Proposed Lake Lothing Third Crossing (TRO10023)

Associated British Ports (20013261)

**Summary of oral submissions made by ABP at the examination hearing held
on Friday 8 March 2019**

Adjourned Compulsory Acquisition Hearing 2

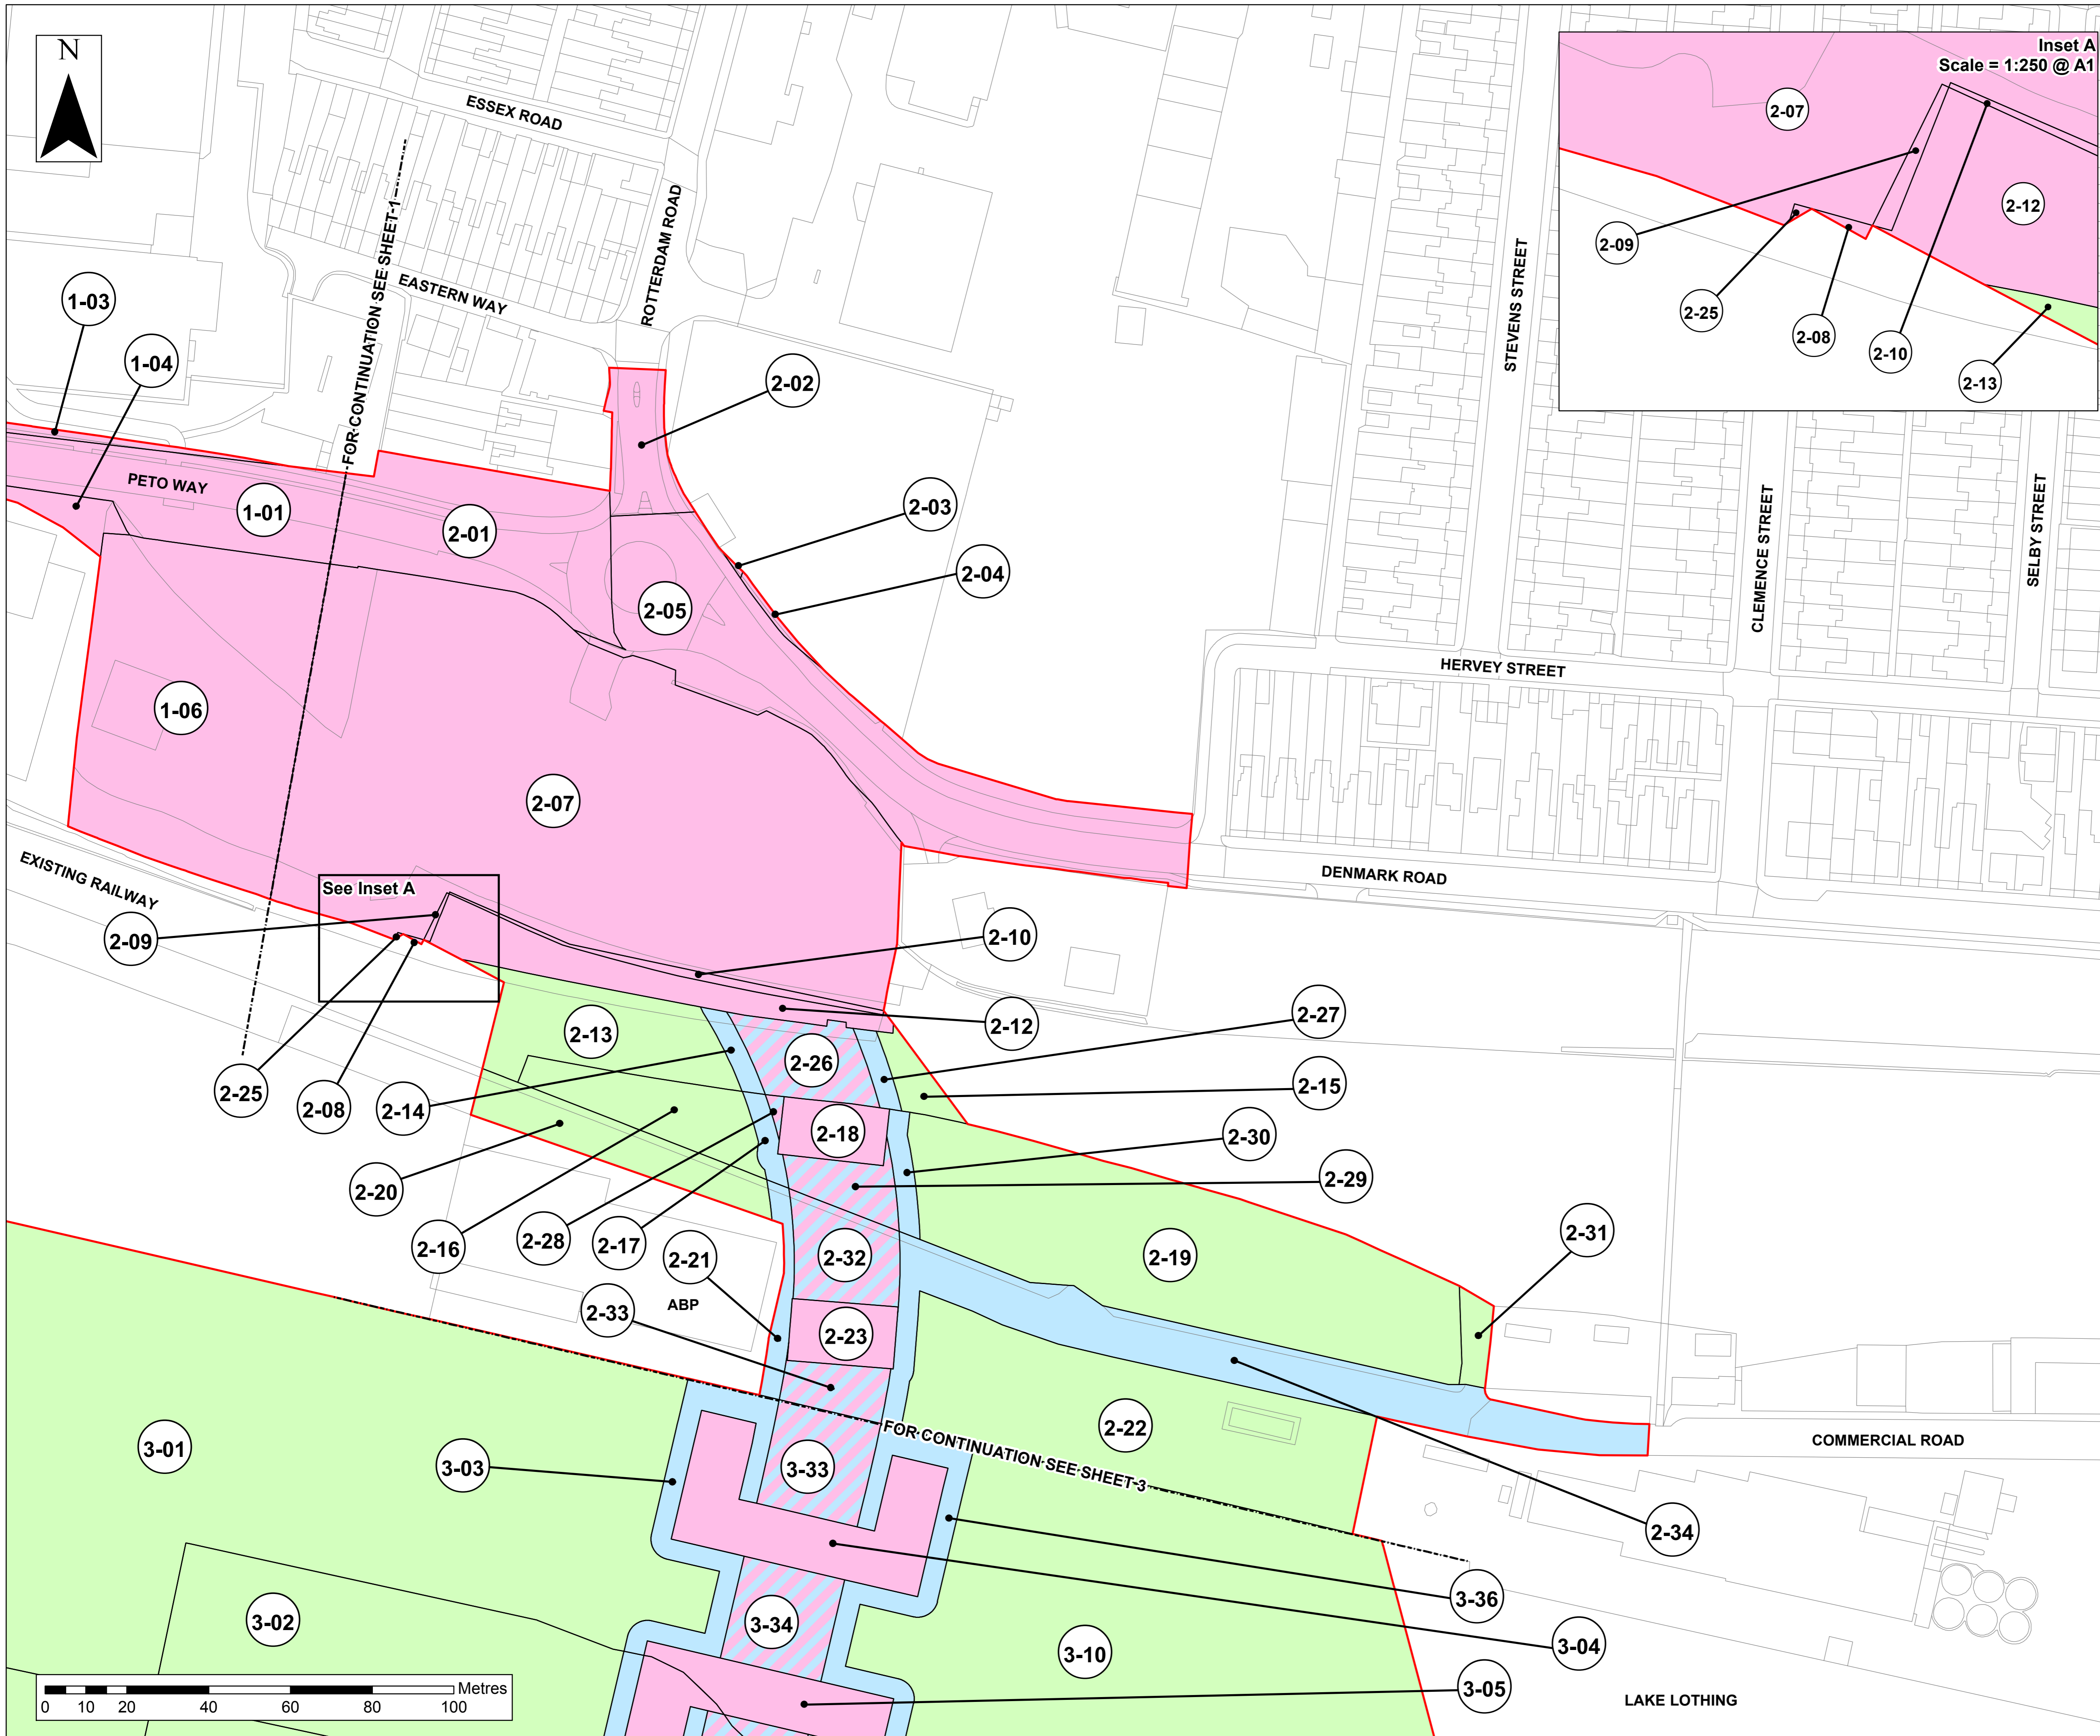
- 1.5 In respect of matters relating to the permanent acquisition of land and airspace within the statutory port estate and the temporary possession of land for the construction of scheme and related impacts in relation to Commercial Road, ABP referred to the Land Plans - Sheet 3 of 5 - which marked the various parcels of land within the port estate over which the Applicant seeks rights and referred also to ABP's submissions in respect of compulsory acquisition outlined in Paragraph 9 of ABP's note on Compulsory Acquisition Matters (ABP: 4 of 5 - DL5).

- 1.9 When looking at the extent of Plot 2-23 on Sheet 3 of the Land Plans against the Engineering Drawings, it is evident that a broad brush approach has been taken with a larger area of land identified on the plans than is actually required for the pillars.

example, that in respect of Plots 3-04 and 3-05 for the bridge supports and the area required to accommodate fenders, the transfer of the entirety of that land is proposed, including the water in channel. Given that these plots are located in areas where there is potential for emergencies to occur, ABP must have access to such areas to carry out its duties as Statutory Harbour Authority, for example, were persons to fall into the water to carry out emergency rescue operations, or in order to provide access for reasons such as repairs, clean-up, contamination/pollution etc. As far as ABP was concerned, it cannot be the case that the whole of the pink areas identified for Plots 3-04 and 3-05 will be required for the solid component of the bridge.

- 1.21 ABP does not see the Applicant's justification for compulsory acquisition of the pontoon (Plot 3-52) and certainly does not understand why the freehold needs to be acquired for the pontoon. As such, ABP requests further information from the Applicant in this regard.

- 1.23 ABP also requires access to those areas of quay wall which abut the bridge for maintenance and repair purposes as they are next to quay wall such as, for example, Plots 3-33.

- 1.25 Similarly, Plot 3-34 (i.e. the central channel) is an area of water that will be subject to vessels regularly passing and re-passing and will need to be suitably dredged for the channel to continue to remain in operation, as well as to carry out maintenance. As broadly set out, the compulsory acquisition of the rights in respect of Plot 3-34 includes both airspace and rights in channel – it is not clear what the implications for ABP as Statutory Harbour Authority will be to maintain that channel. ABP cannot, however, accept any constraints in this respect.

- 1.13 The Applicant in response indicated that the precise scheme details had not yet been finalised, and whilst the full extent of some of the parcels of land identified may not ultimately be required the plans have been submitted as drafted in the context of the Rochdale envelope principle.

- 1.14 The Applicant also stated that the way the DCO is structured means that no acquisition can take place without ABP's agreement, not to be unreasonably withheld. Mr Robbie Owen (on behalf of the Applicant) suggested that Articles 20 and 22 of the draft DCO provided that the Applicant will be required to carry out further internal testing processes to establish whether land is required for the scheme if the DCO is
